KIRKLEES METROPOLITAN COUNCIL INVESTMENT & REGENERATION SERVICE

DELEGATED DECISION TO DETERMINE PLANNING APPLICATIONS

Reference No:	2024/62/91594/W
Site Address:	1, Dryclough Avenue, Crosland Moor, Huddersfield, HD4 5JU
Description:	Erection of single storey side and rear extensions
Recommending Officer:	Laura Yeadon

DECISION – REFUSED

Drawing
Layout and Location Plan

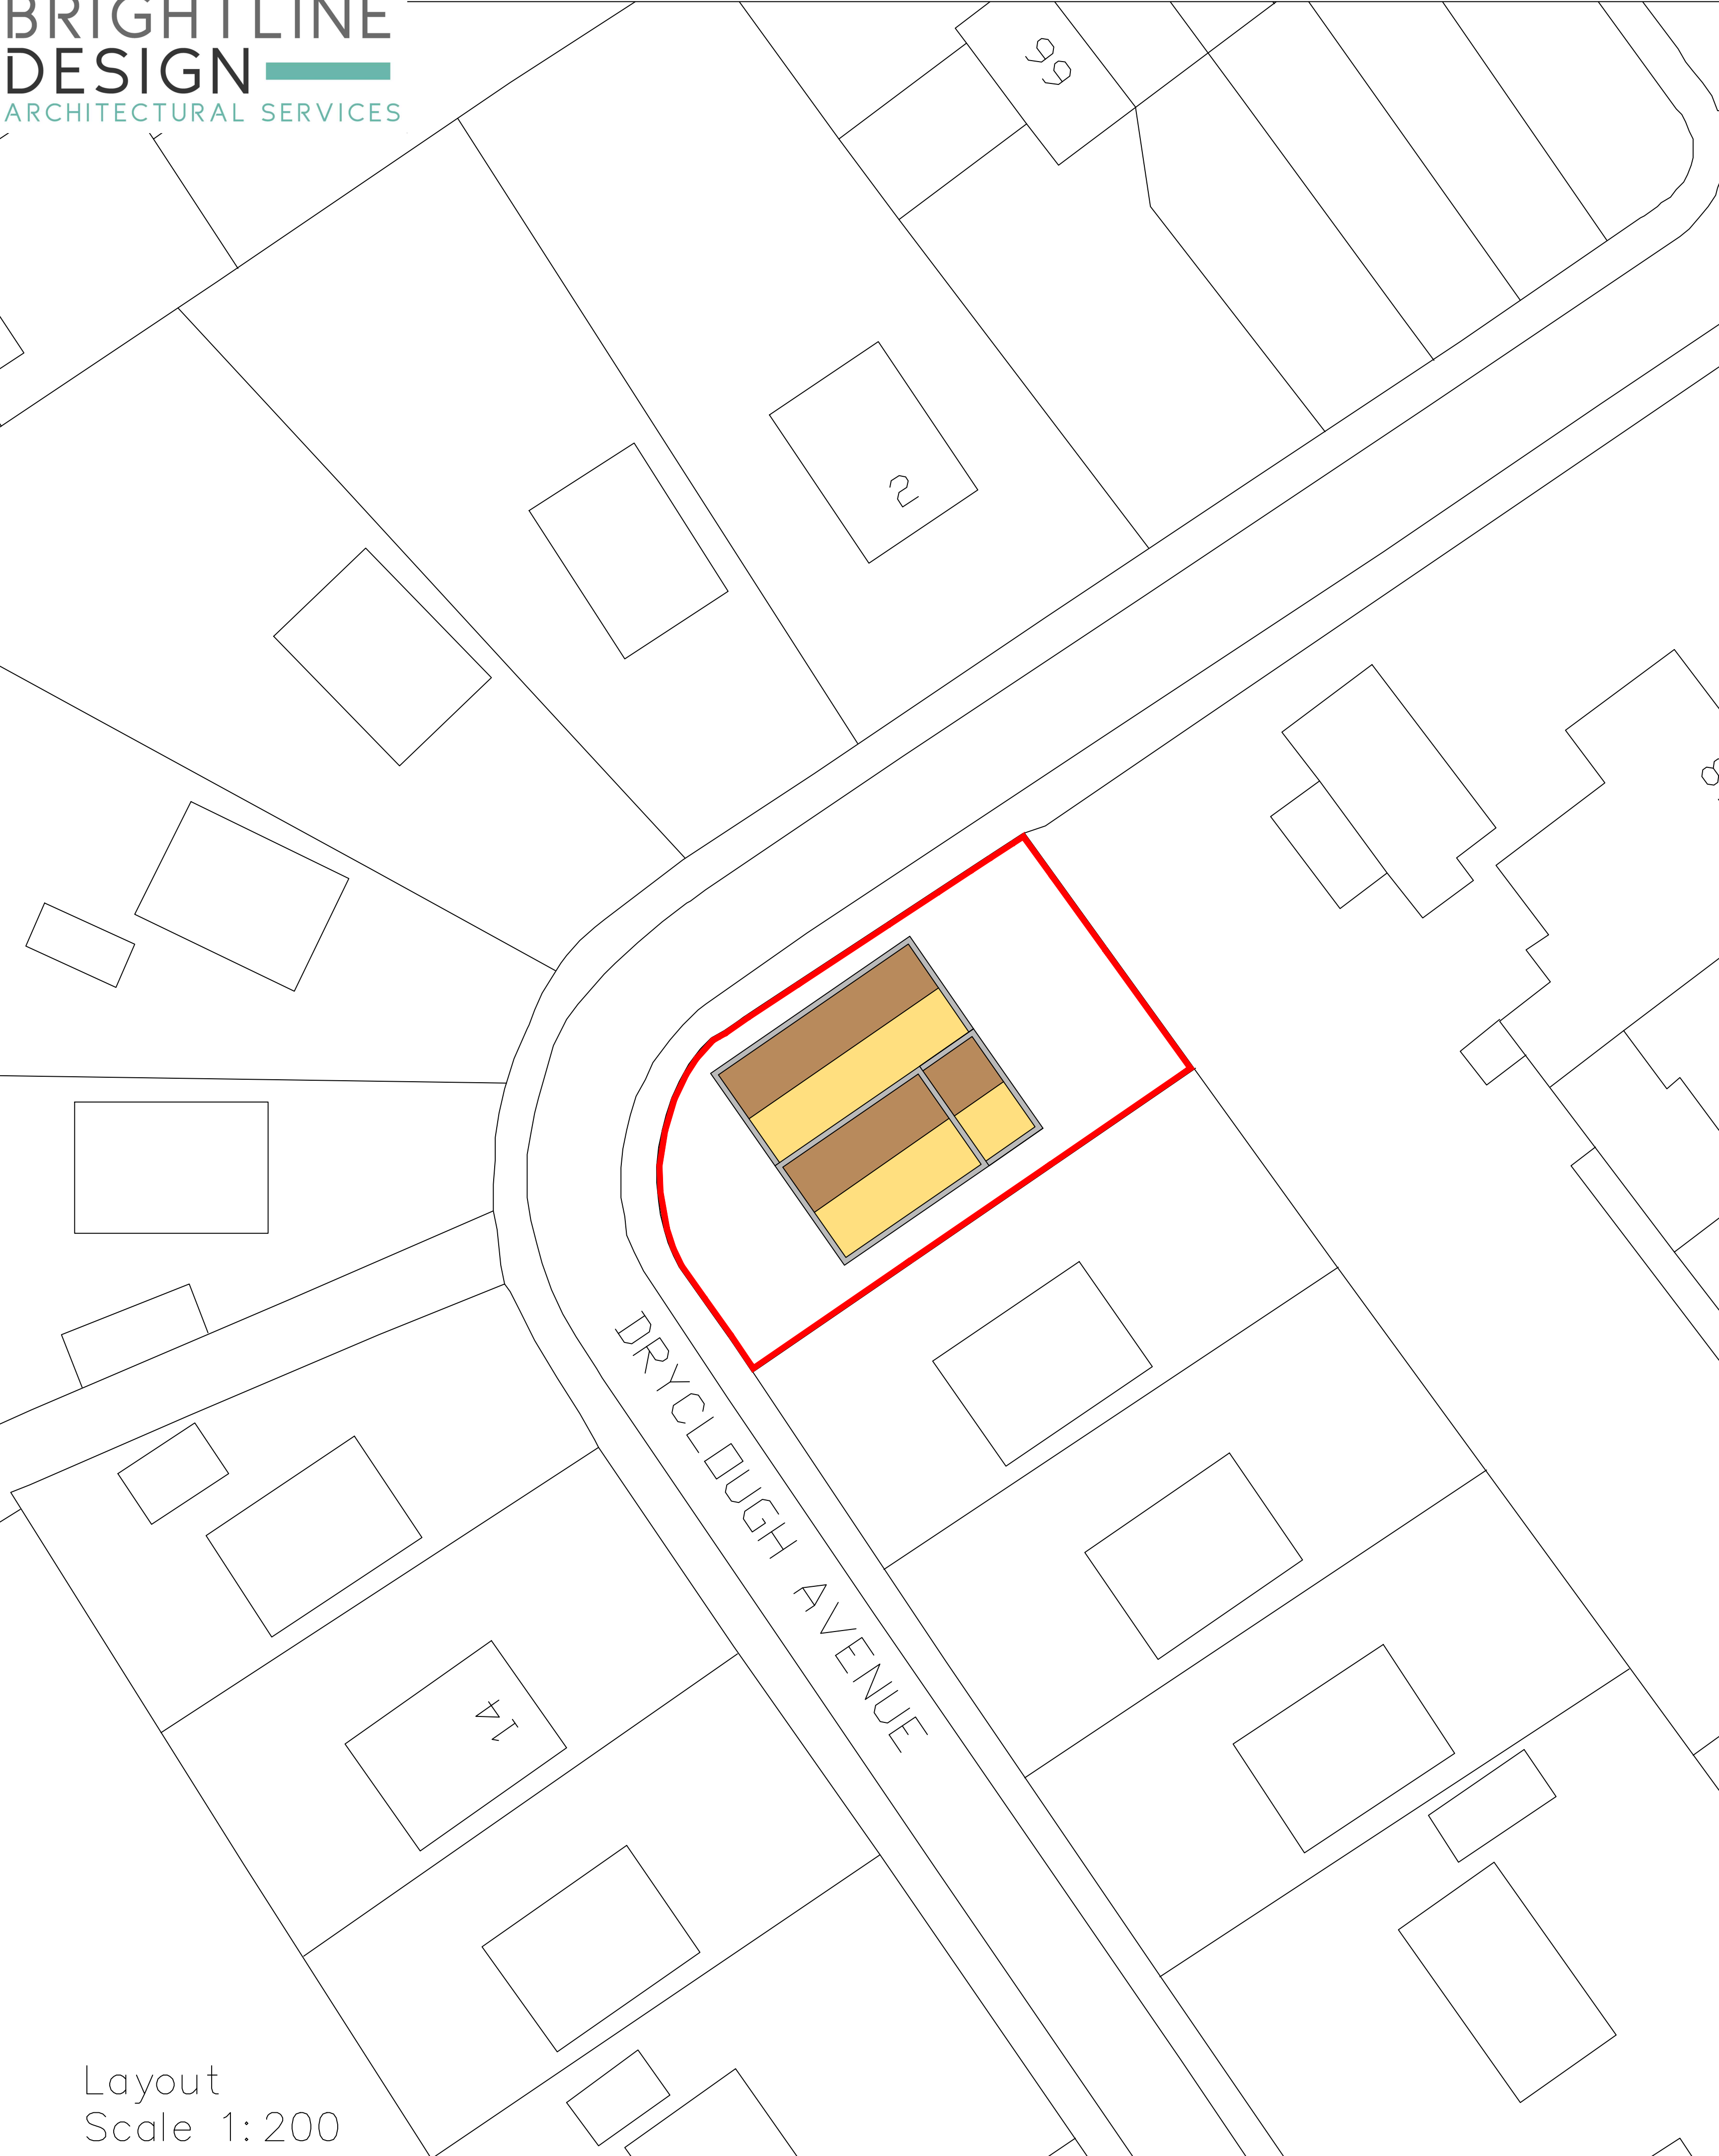
The property does not appear to have been previously extended. The submitted proposed layout plan indicates that the amenity space to the front and rear would be retained with the amenity space to the side lost to the proposed side extension. The rear amenity space would be reduced due to the presence of the rear extension however it would appear that the driveway to the rear of the property would be retained. It is noted that sub-paragraph 4.22 of the House Extensions and Alterations SPD states that normally, front gardens will not normally be considered adequate useable private amenity space due to the lack of overall privacy for occupants. In this case the retained level of amenity space is considered to be acceptable.

In this case it is proposed that the property would have 4 no. bedrooms and therefore 3 no. parking spaces are required to be achieved, off-street, in order to comply with the SPD. It appears on the proposed layout plan that the detached garage would be removed from the site. The driveway and existing garage appear to extend approximately 15 metres which would provide space for 2 no. vehicles to sit comfortably on the driveway. Whilst on-street parking is not ideal, there are no on-street parking restrictions along the Avenue and therefore, in this case, it is not anticipated that the works would result in a development that would be so harmful to highway safety that there would be sufficient justification to refuse the application on the basis of the level of parking which could be provided. As such as it is considered that the highway safety impact, and provision of parking, would be acceptable and the proposal complies with Policies LP21 and LP22 of the Kirklees Local Plan and Key Design Principle 15 of the SPD.
